CITY OF ALBUQUERQUE

Re: Lot 12, Sauvignon Subdivision Grading and Drainage Plan
Engineer's Stamp date 04-30-12 (E-22/D007F7)

Based upon the information provided in your submittal received 05-01-12, the above referenced plan cannot be approved for Building and Grading Permit until the following comments are addressed:

ENGINEER'S SEAL	LOT 12 THE SAUVIGNON SUBDIVISION	DRAWN BY WCUJ
	GRADING AND DRAINAGE PLAN	DATE 4-26-12
	 <i>Rio Grande Engineering</i> 1606 CENTRAL AVENUE SE SUITE 201 ALBUQUERQUE, NM 87108 (505) 872-0899	21212-LAYOUT-4-26-12
DAVID SOULE P.E. #14522		SHEET #  HYDROLOGIST # SECTION 21212

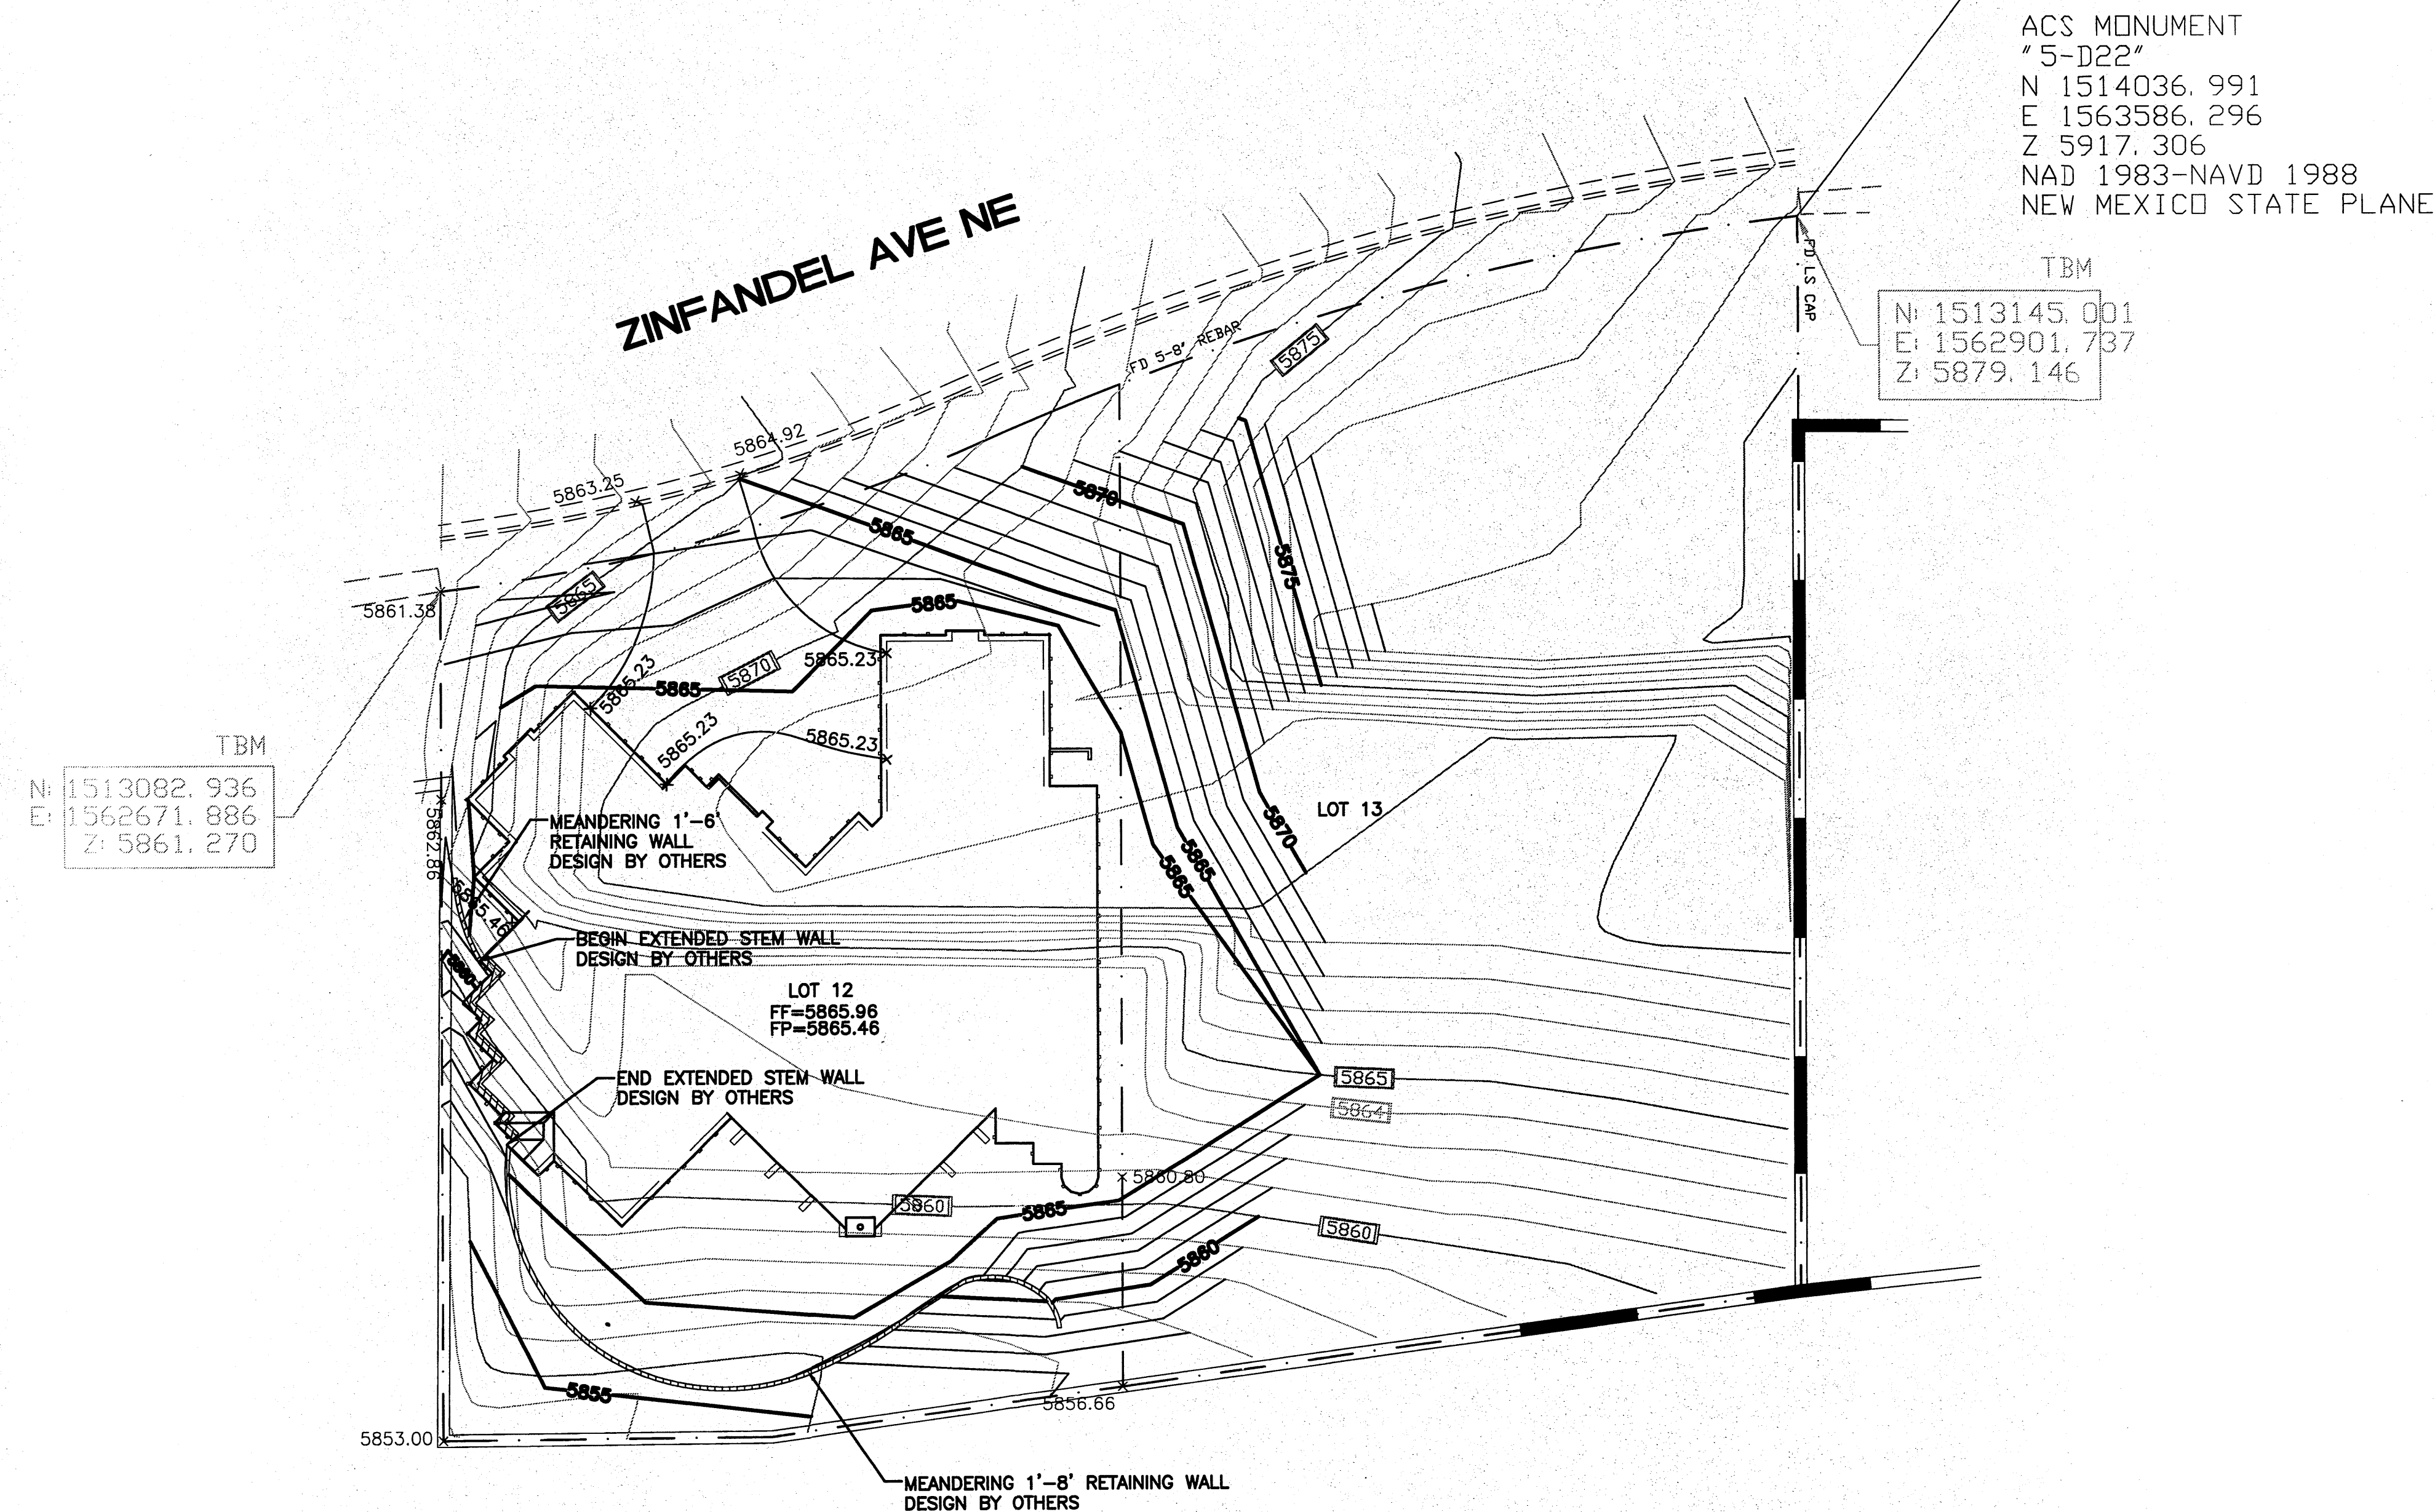
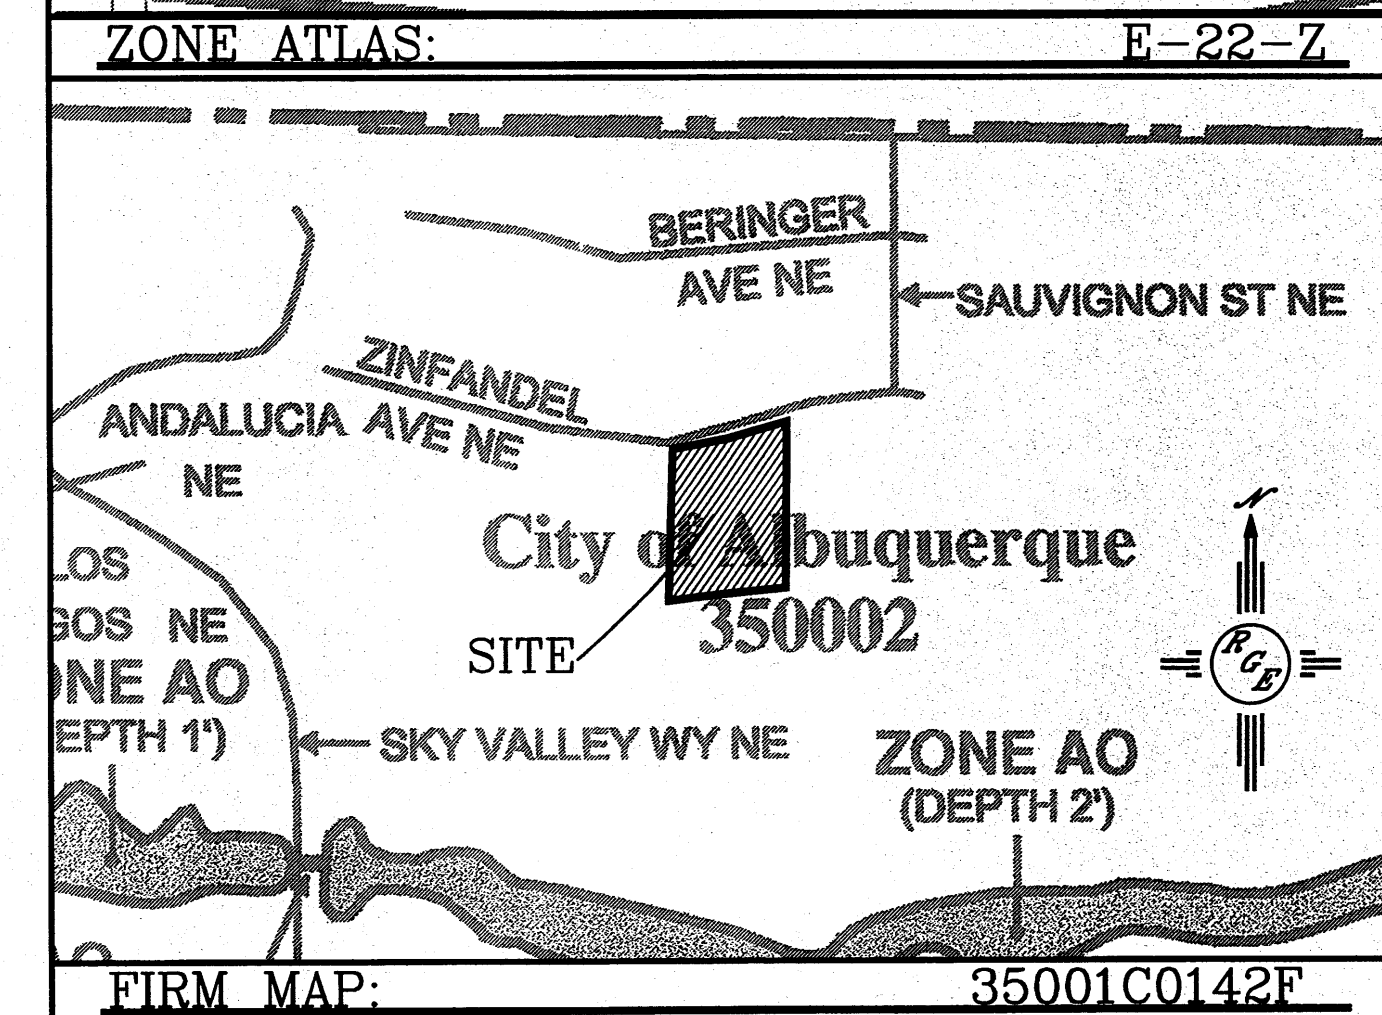
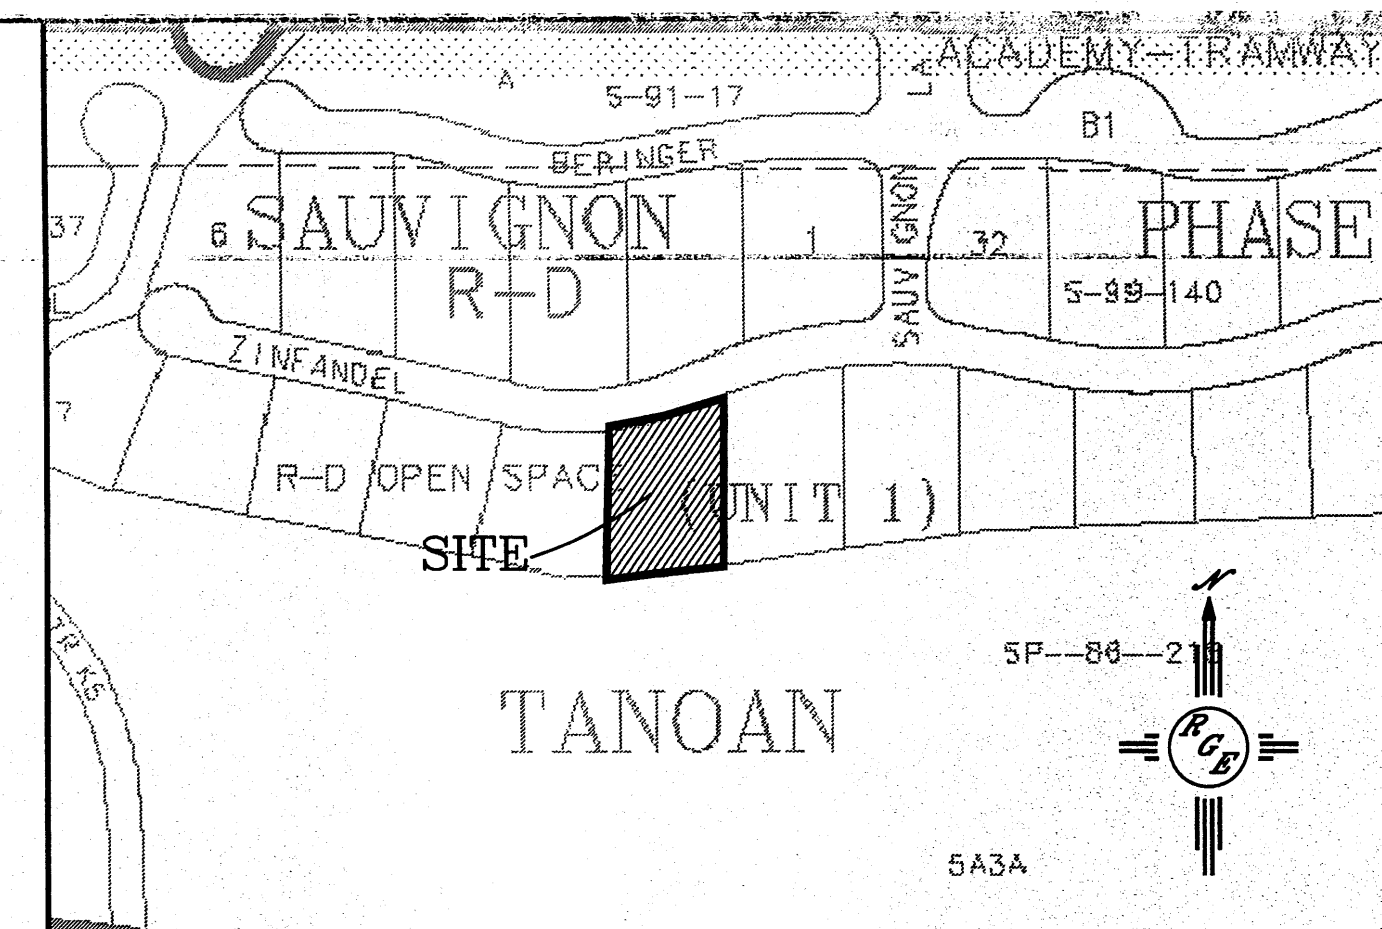
- Please provide a copy of the referenced master drainage plan for this lot indicating the allowable free discharge rate.
- In order for grading to be performed on the adjacent lot (Lot 13) a signed document must be submitted with the plan stating that the pad on Lot 13 will be impacted due to this construction activity. This document must be approved and signed by the adjacent property owner.
- Hydraulic calculations might be required based on information contained within the master drainage plan.
